**East West Rail Network Phase 2 The Scheme  
Railway From London Road Bicester To Station  
Road Launton**

**20/03102/DISC**

**Proposal:** Discharge of condition 7 (a)(b)(i) (landscaping proposals at Bridge 36AA Charbridge Lane) of 18/01430/TWAO

Drawing Title
**TWAO PLANNING
CONDITION 7
CHARBRIDGE LANE (OXD/36AA)
VEGETATION REMOVAL DRAWING**

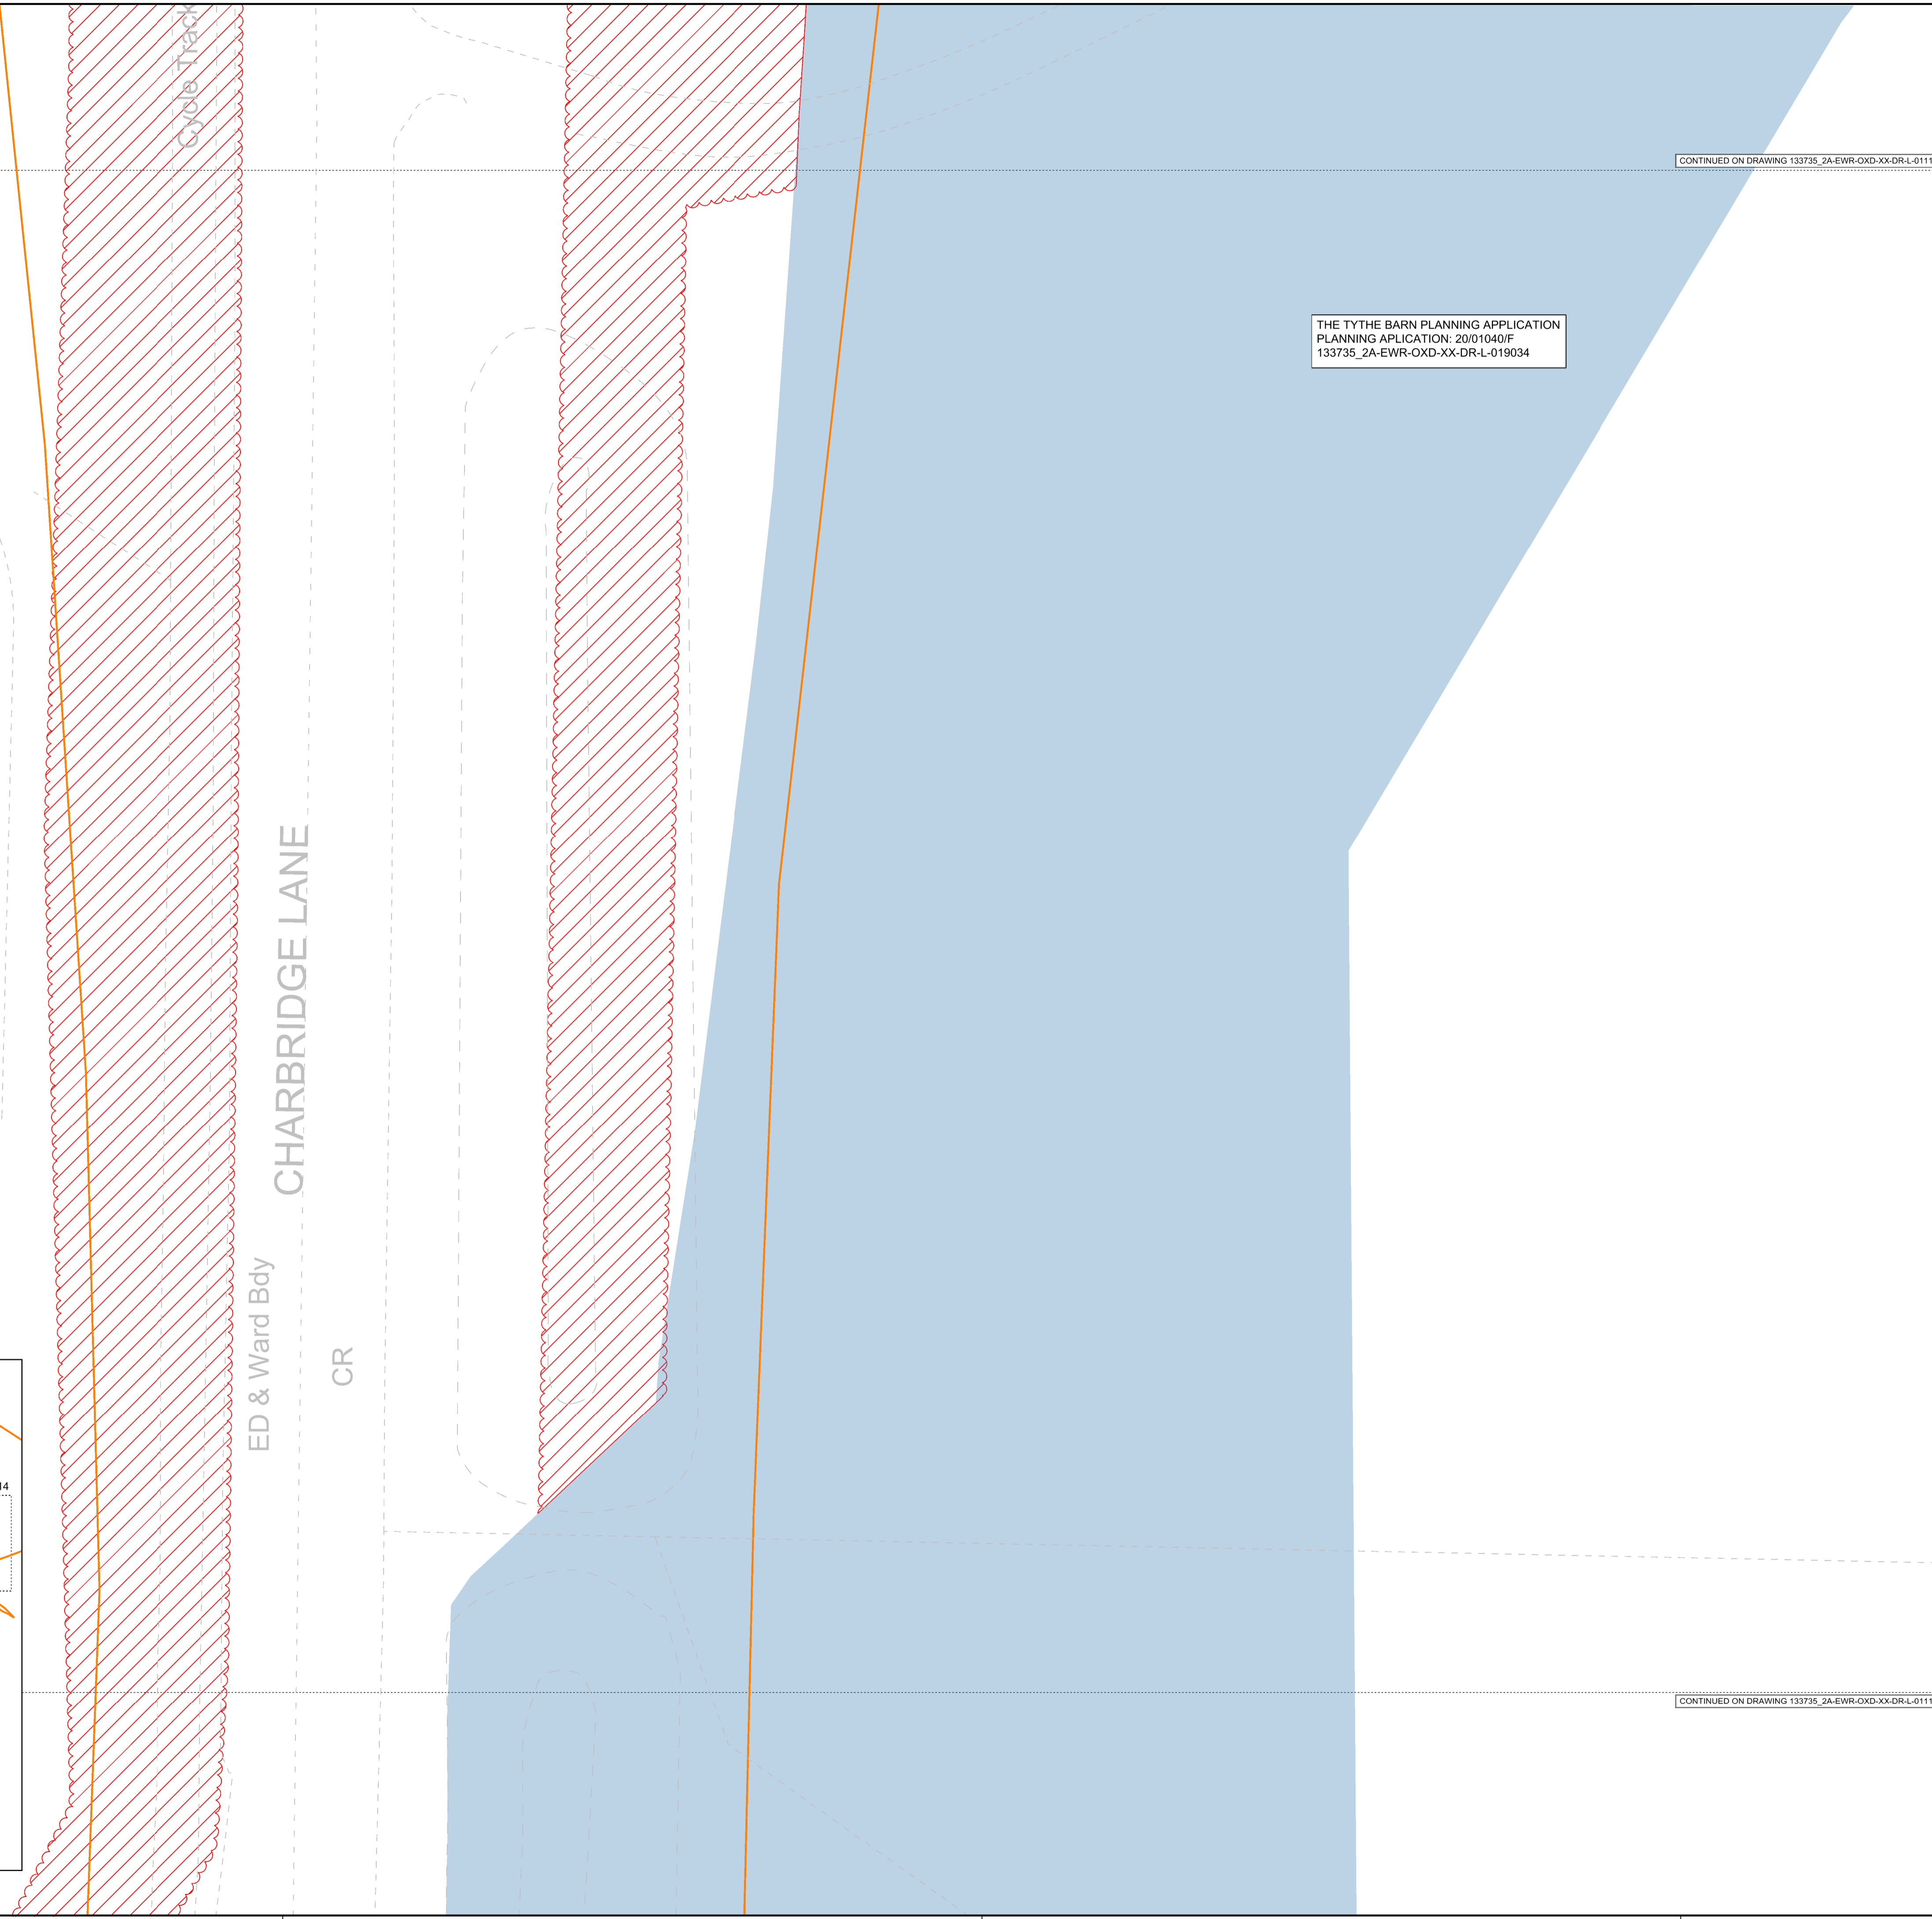
4.1 Landscape Officer, CDC – concern raised about amount of structural vegetation to be removed, as this is a viable amenity resource and wildlife habitat. Queried whether some could be retained? Also suggested that some tree planting could occur in the wide verge between the road and Tythe Barn boundary.?

5.1 The application submission was assessed by the CDC Landscape Officer who expressed some concern about the amount of existing vegetation to be removed and suggested that some could be retained for amenity and biodiversity. The applicant was asked to consider this and has commented advising that the vegetation required to be removed along Charbridge Lane is in connection with the new Tythe Barn access, which has been considered separately. In terms of additional planting within the highway verge along the east side of Charbridge Lane, the Alliance considers this to be unsuitable on safety grounds and much of this verge is within the new visibility splay for the Tythe Barn access.

- 5.2 Having regard to the above comments, whilst the amount of vegetation proposed to be removed overall is somewhat disappointing, the explanation given above is accepted as reasonable and the application is therefore recommended for approval accordingly.
- 5.3 The original application was EIA development. The application submission seeks to deliver the landscaping scheme set out in the original submission and has no additional environment impacts above those already considered in the original ES. Therefore, the EIA is considered sufficient for the purpose of considering the information provided for this condition and it has been taken into account in considering this subsequent application.
